Appeal Decision

Appeal Ref: APP/R4408/W/20/3255913

The Old Corn Mill, Manchester Road, Thurlstone S36 9PT

- The appeal is made under section 78 of the Town and Country Planning Act 1990 against a refusal to grant planning permission.
 - The appeal is made by Gerald Trew against the decision of Barnsley Metropolitan Borough Council.
 - The application Ref 2019/1042, dated 10 August 2019, was refused by notice dated 26 March 2020.
 - The development proposed is two detached houses.
-

CORN MILL SITE - HOUSING LAYOUT, SCALE 1:100 DRG A4 8/2019

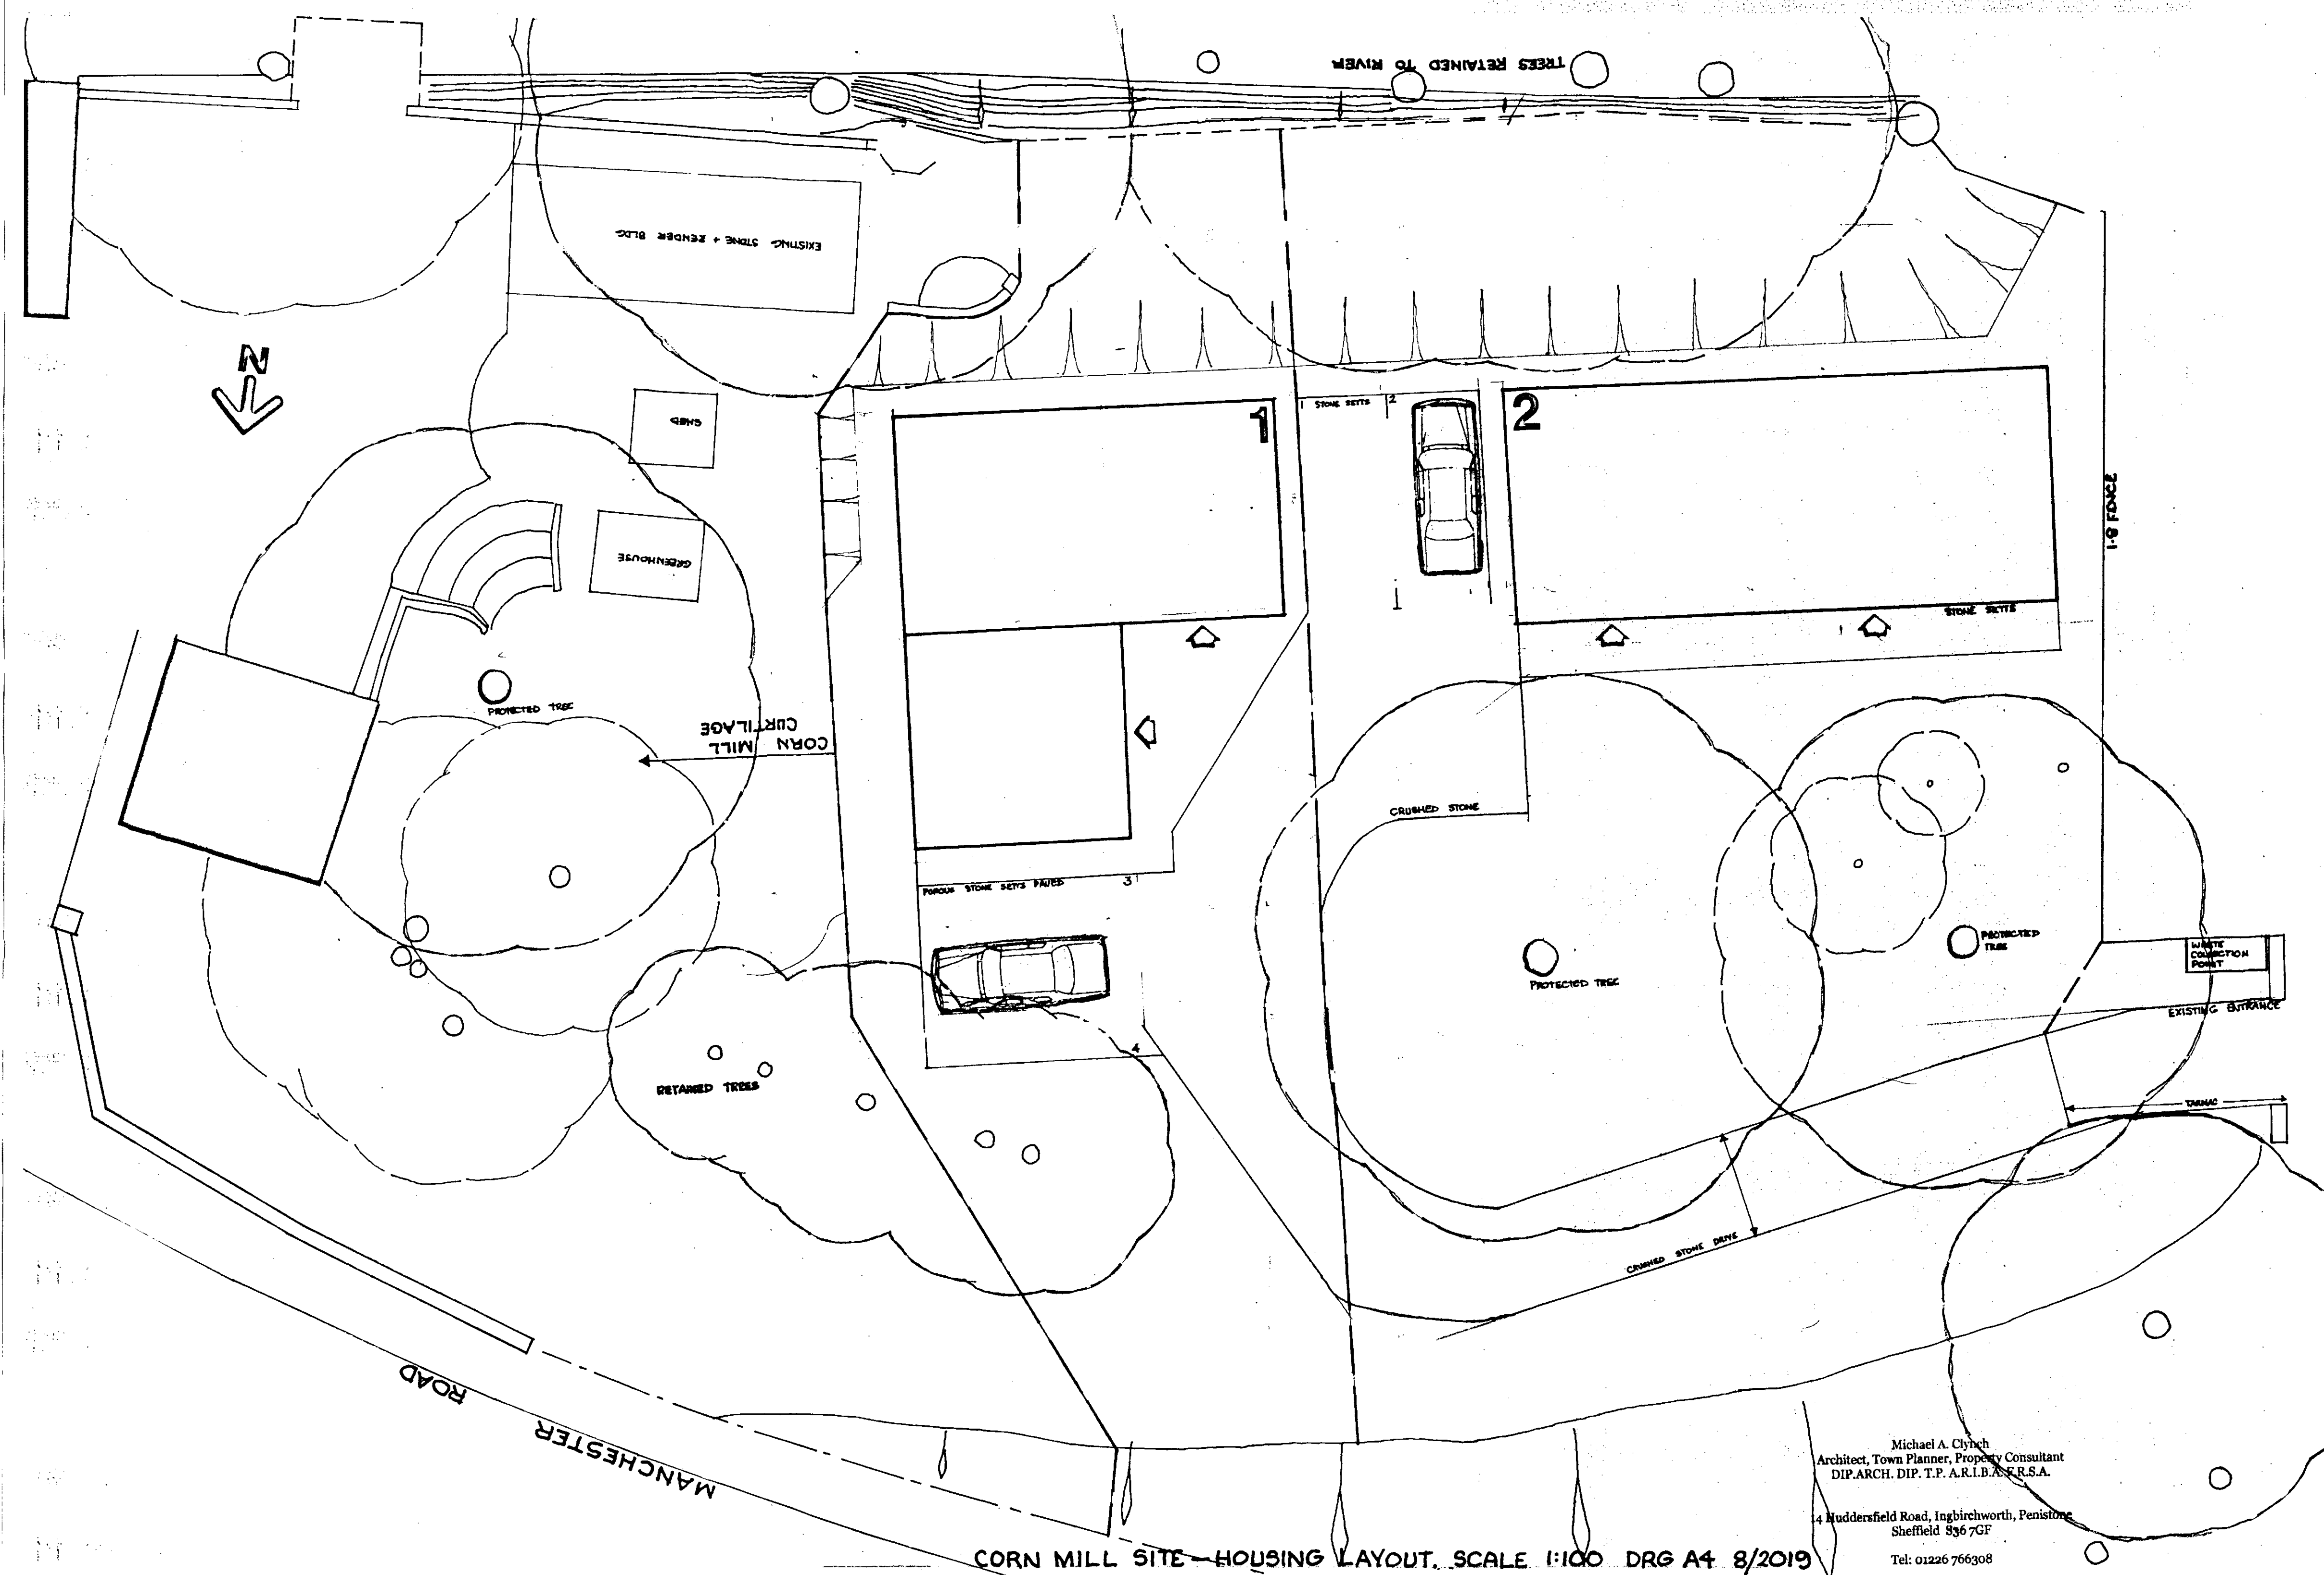
9. The dwellings would be located parallel to the river, in the rear half of the site. Their overall design and simple typology would sit well with the rather functional design of the nearby period buildings. Their placement would also enable the retention of some of the open space that abuts Manchester Road, thus retaining the relationship between the original village structures, and in particular, the setting of Tenter Hill. In principle, I am satisfied that sympathetic development on this site would not necessarily harm the significance of the TCA or the setting of Tenter Hill.

11. The appeal site slopes down from the road to the river. There is limited topographic survey information before me and no finished floor levels (FFL). Dwelling 1 would project further into rising ground than dwelling 2 and according to such ground levels as there are, it appears that the dwellings would not necessarily have the same FFLs. Consequently, I am unclear how much regrading would be required to accommodate the dwellings and hardstanding areas, or how high the dwellings would be relative to the road. This is of particular concern in relation to dwelling 1 which has a significant

three storey element, and which would in any case be significantly higher than Old Corn Mill. The development's size and scale could appear overly dominant and regimented in this context, particularly given the modest scale of the buildings opposing the appeal site. They could also represent substantial encroachment into the open space abutting the road which has significance in relation to the TCA and the setting of Tenter Hill.

12. On the basis of what is before me I conclude that the dwellings would be prominent in the street scene and their combined bulk and scale would appear disproportionately large and dominant in this context. Moreover, I am not satisfied that they would be adequately screened by retained trees, discussed further below. As such, I am unable to conclude that the development would not be detrimental to the TCA or the setting of Tenter Hill.

16. One line of conifers would be retained and would provide some screening from the east, but they would be located close to the parking area and as such likely to come under pressure for removal, as outlined below.

18. However, the development would require the establishment of a level platform on which to build. I have concerns that the retained trees would be affected by changes in ground level, particularly those along the river bank where some Root Protection Zones extend beyond the dwellings' footprint and into the area of raised ground.

19. Moreover, as most of the retained trees would be close to or oversail the dwellings it is highly likely that they would come under pressure for removal or significant pruning. This is a particular concern for dwelling 2 which has windows only on its northern and southern elevations, both of which would be close to tree canopies. In my experience there is little tolerance of the shade and debris cast by mature trees in proximity to dwellings. Light entry would be

28. In any case, the flood risk map submitted shows that part of the footprint of both proposed dwellings would be in Flood Zone 2. Although I appreciate that site levels could be altered to raise the dwellings, the FRA does not give water levels in the event of flooding. The EA maps are small scale and can only provide guidance. Without information regarding potential flood levels, related to site datum, I am unable to conclude that raising the dwellings as proposed, would lift them above flood water. Moreover, groundworks required to raise levels could be detrimental to the future health of the riverbank trees.
